**CHEROKEE METRO DISTRICT COMMENT:**

PUD PRELIMINARY PLAN MINOR AMENDMENT
 OVERALL SITE PLAN AND ADJACENT OWNERS

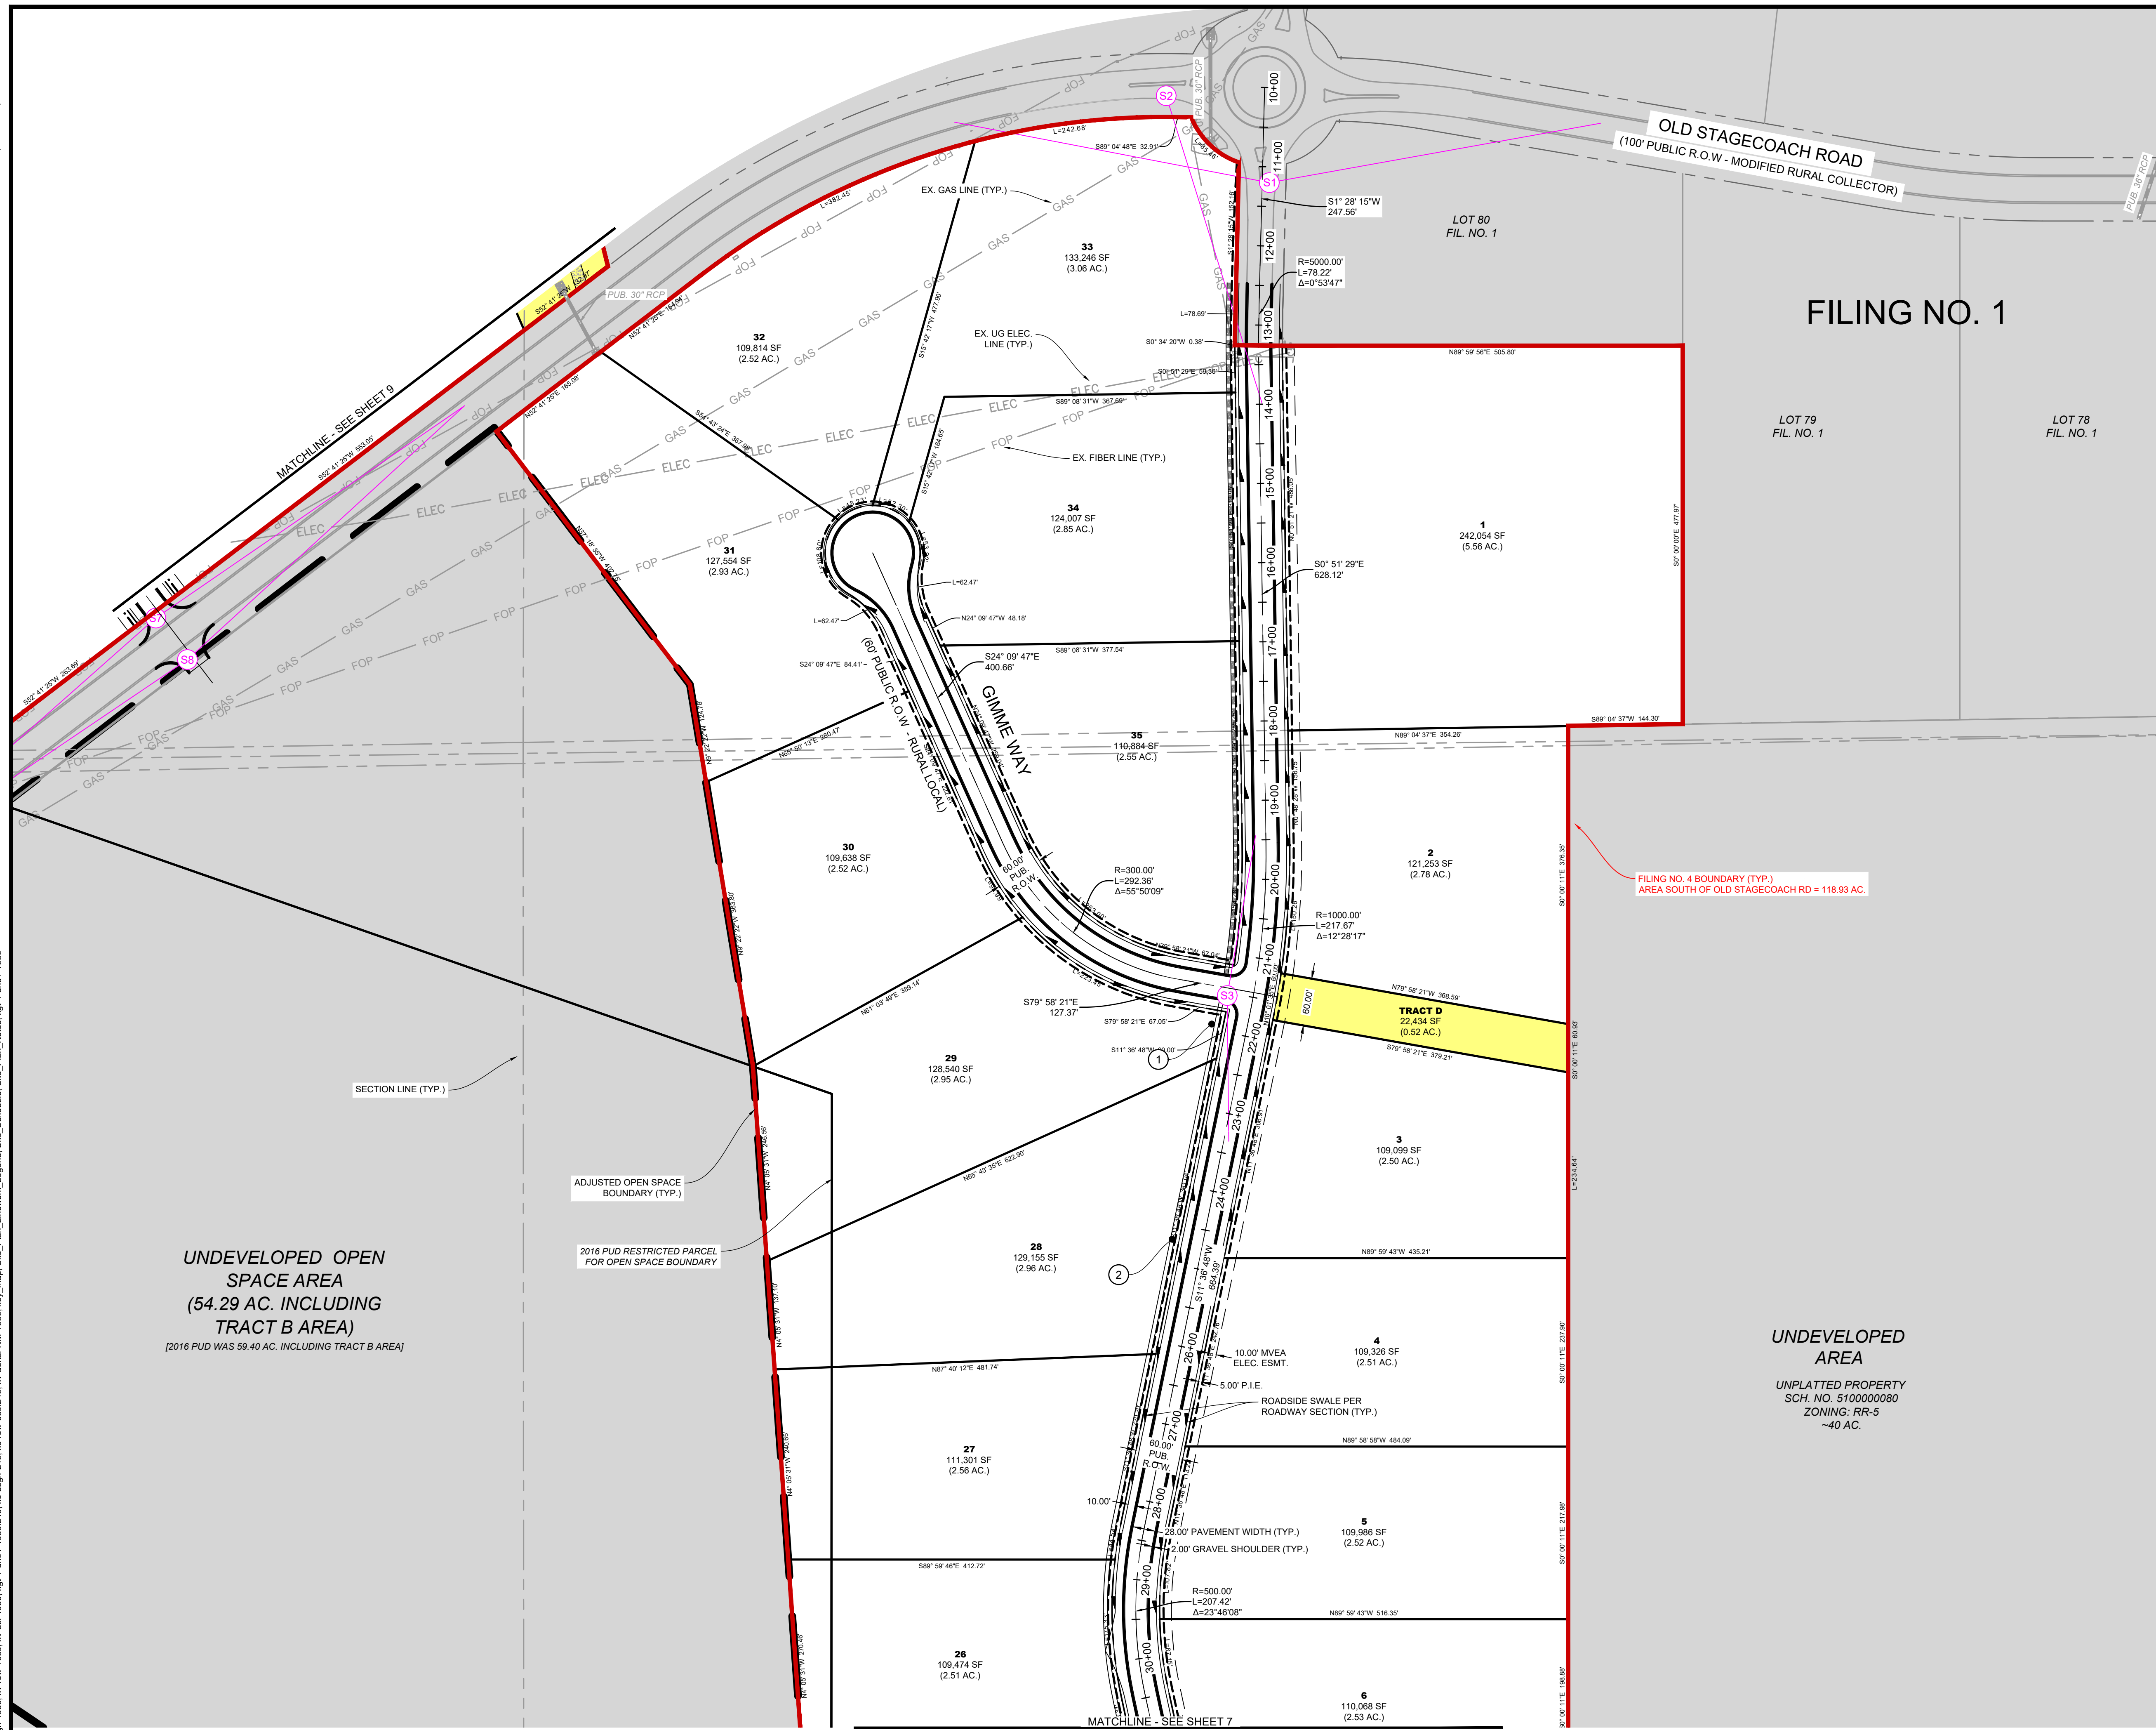
Development plan needs to include water and wastewater plans. Cherokee Metropolitan District does have a varying 20" to 24" main conveyance pipeline running through your site area. Tie is possible but it needs to be understood that a tie into a main conveyance line will be logistically more difficult and expensive to the development. Cherokee has no wastewater lines in this developments area. Cherokee almost always will not provide water to an area that we cannot reclaim the wastewater to treat and keep within our system. Either way utility plans for water and wastewater need to be included in the plans for approval, whether Cherokee Metro provides the water or another provider

All utilities associated with FHN #4 are shown in the Construction Document set that was uploaded with the plat. There are not specific water or utility designs for these 2.5-acre lot minimums since they will be served by well and septic. Our team would like to setup a call with Cherokee to understand where current infrastructure exists in FHN. This could have potential impacts to proposed lots.
